J. S. Jones and Associates, Inc.

RE: 4346 E. Mercer Way, Critical Area Determination (CAO17-003)

Please find attached the 2nd revised Critical Area Study and Watercourse and Wetland Buffer Reduction Report for CAO17-003 originally submitted on March 8, 2017 and revised on March 24, 2018. This updated report has addressed the recommendations by the City of Mercer Island’s ESA Peer Review Memorandum dated May 15, 2018. In the previous response from June 20, 2017, the applicant addressed all of ESA’s comments with the exception of the detail of the trail as outlined in item #10 in this response. This has now been corrected.

SHEET
3 OF 5

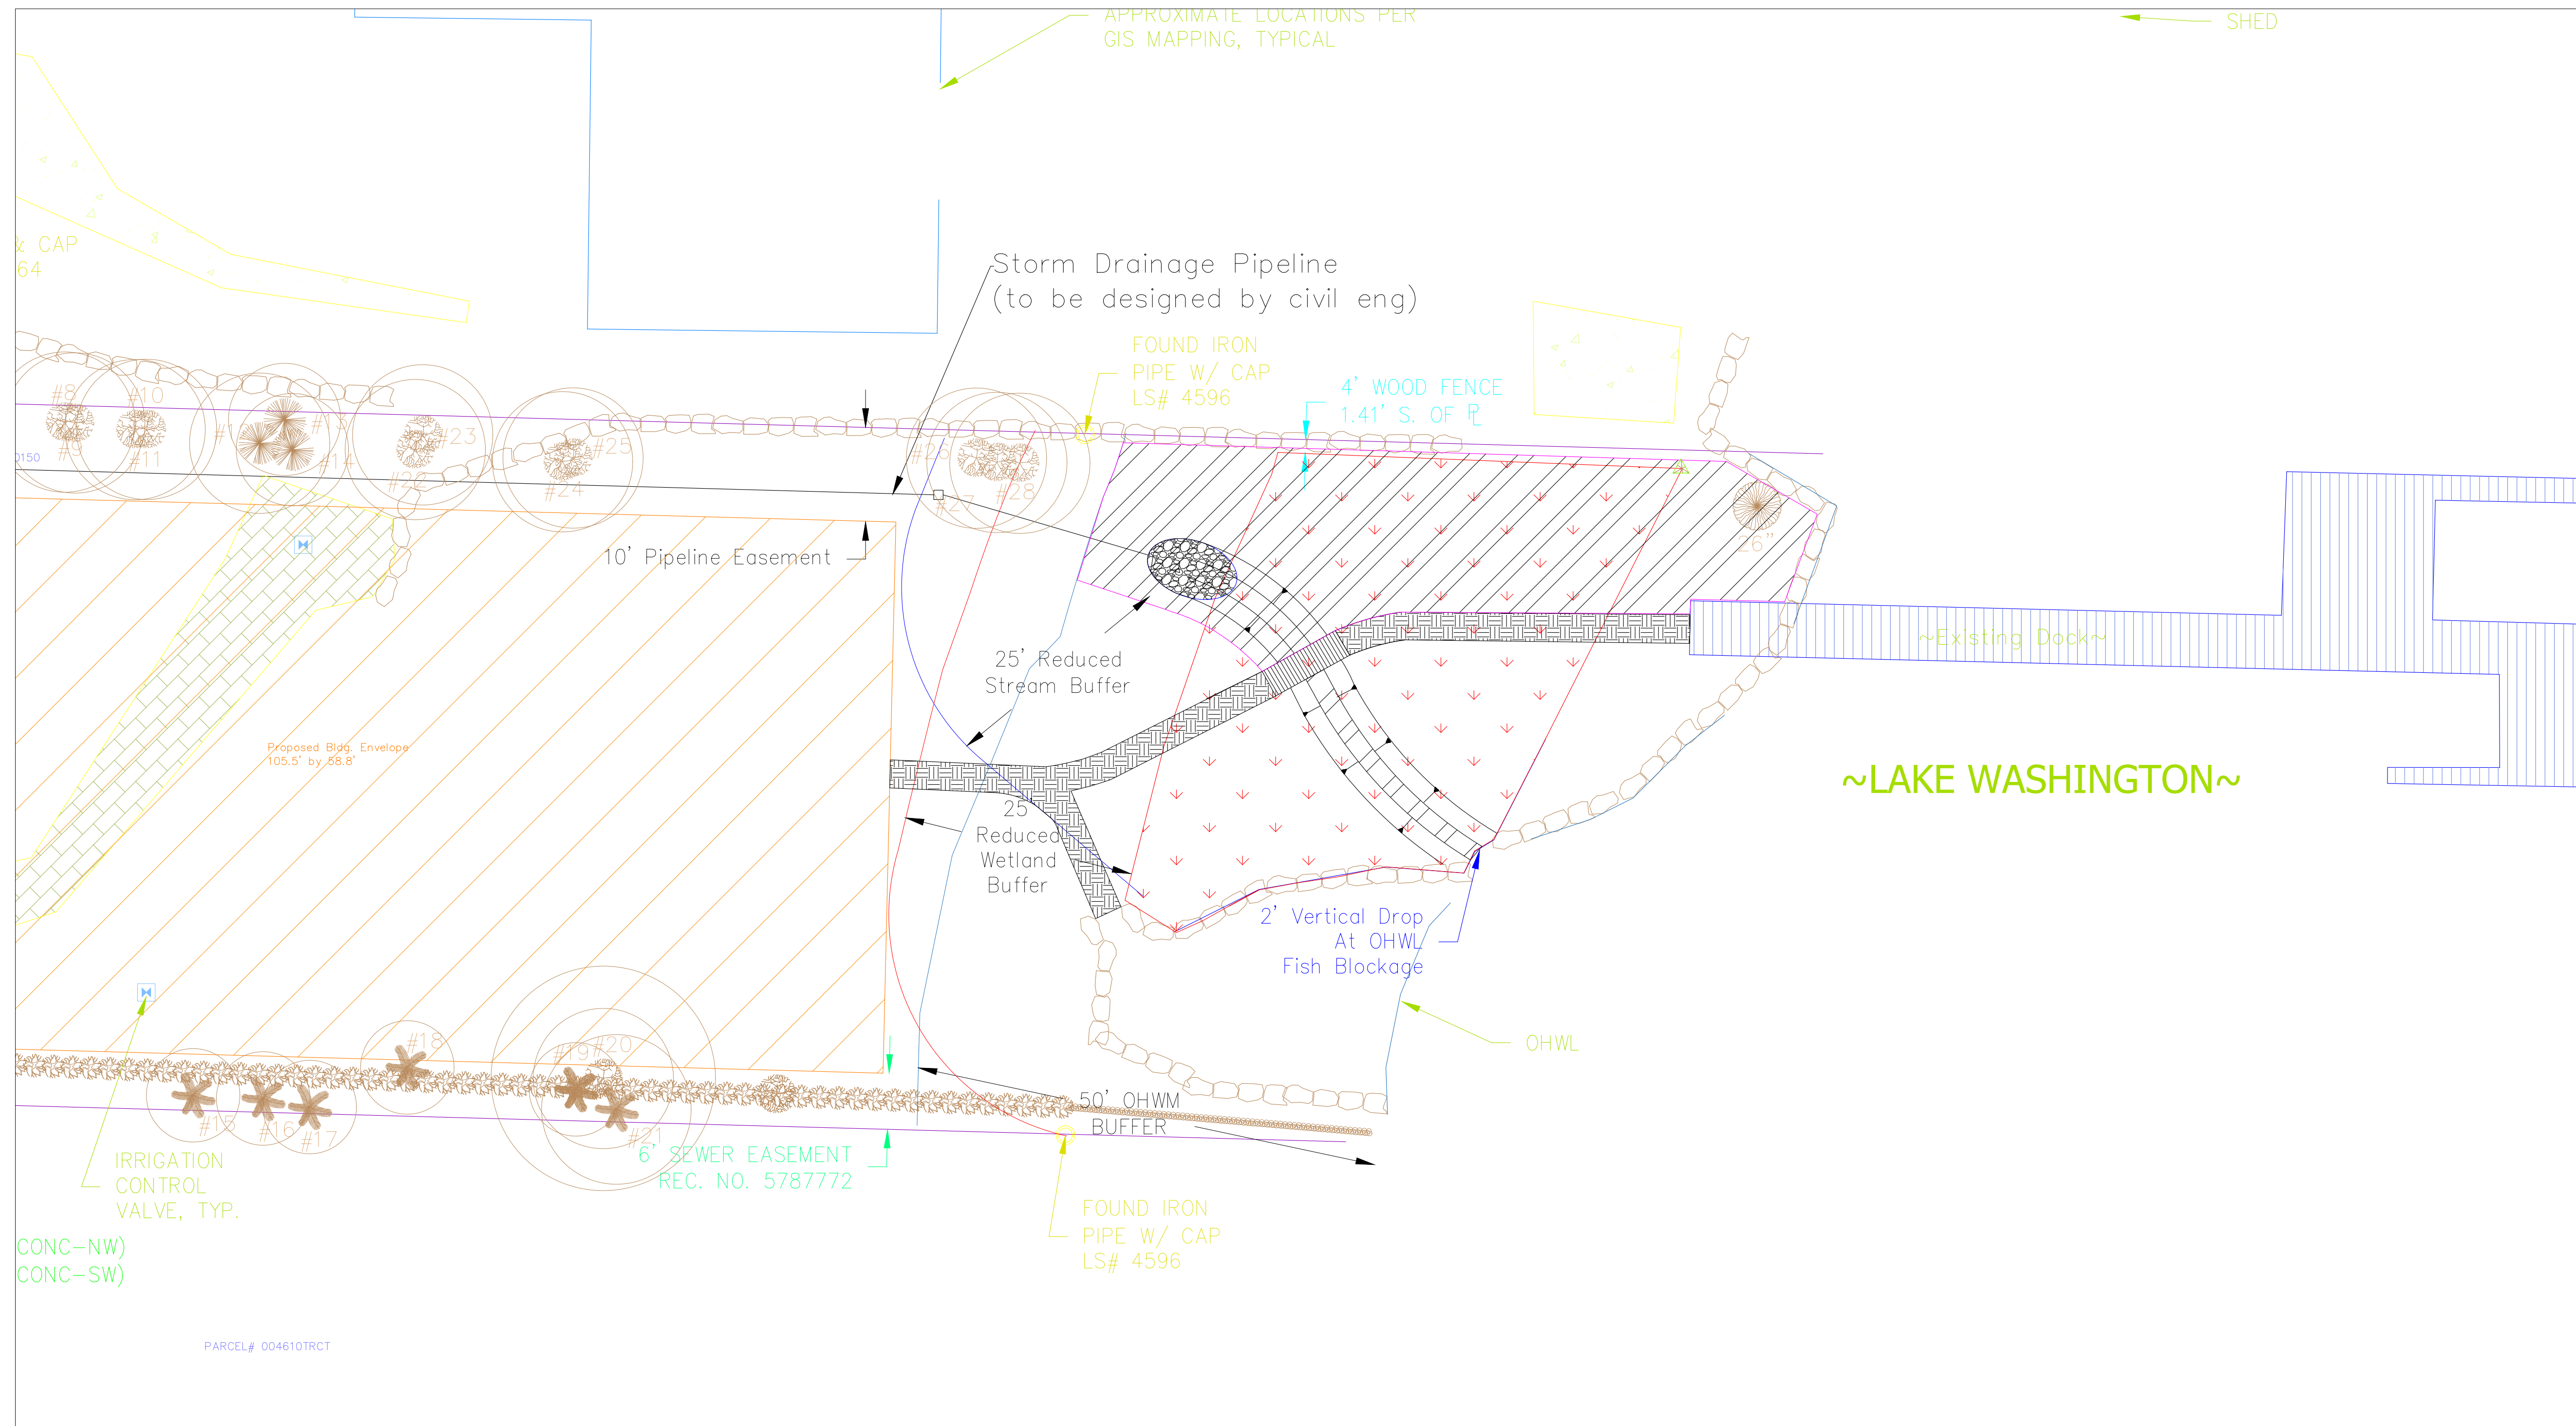
2. On the plans, the walkway from the elongated parking area leading to the proposed house is labeled as a trail. This area is a walkway, not a trail. Please relabel as walkway. Walkways are not allowed in buffers, so the walkway must be removed from the reduced buffer area.	The applicant has revised plans to remove the walkway from the reduced buffer area.

<p>4. A portion of the proposed driveway including the parking area at the terminus of the driveway is parallel with the water course within the buffer and is located within the reduced watercourse buffer. While driveways are allowed in buffers pursuant to MICC 19.07.030(A)(9), the layout is not consistent with best available science and does not avoid impacts to the reduced watercourse buffer. Best available science allows driveways to be placed in buffers perpendicular to critical areas to pass through or cross over the critical area. Please realign the driveway to be perpendicular to the watercourse to ensure no net loss of watercourse and buffer functions; a revised site design is appropriate.</p>	<p>Per best available science and to avoid impact to the reduced buffer, applicant has revised the site design and repositioned driveway almost entirely outside the reduced buffer area and perpendicular to the piped watercourse.</p>
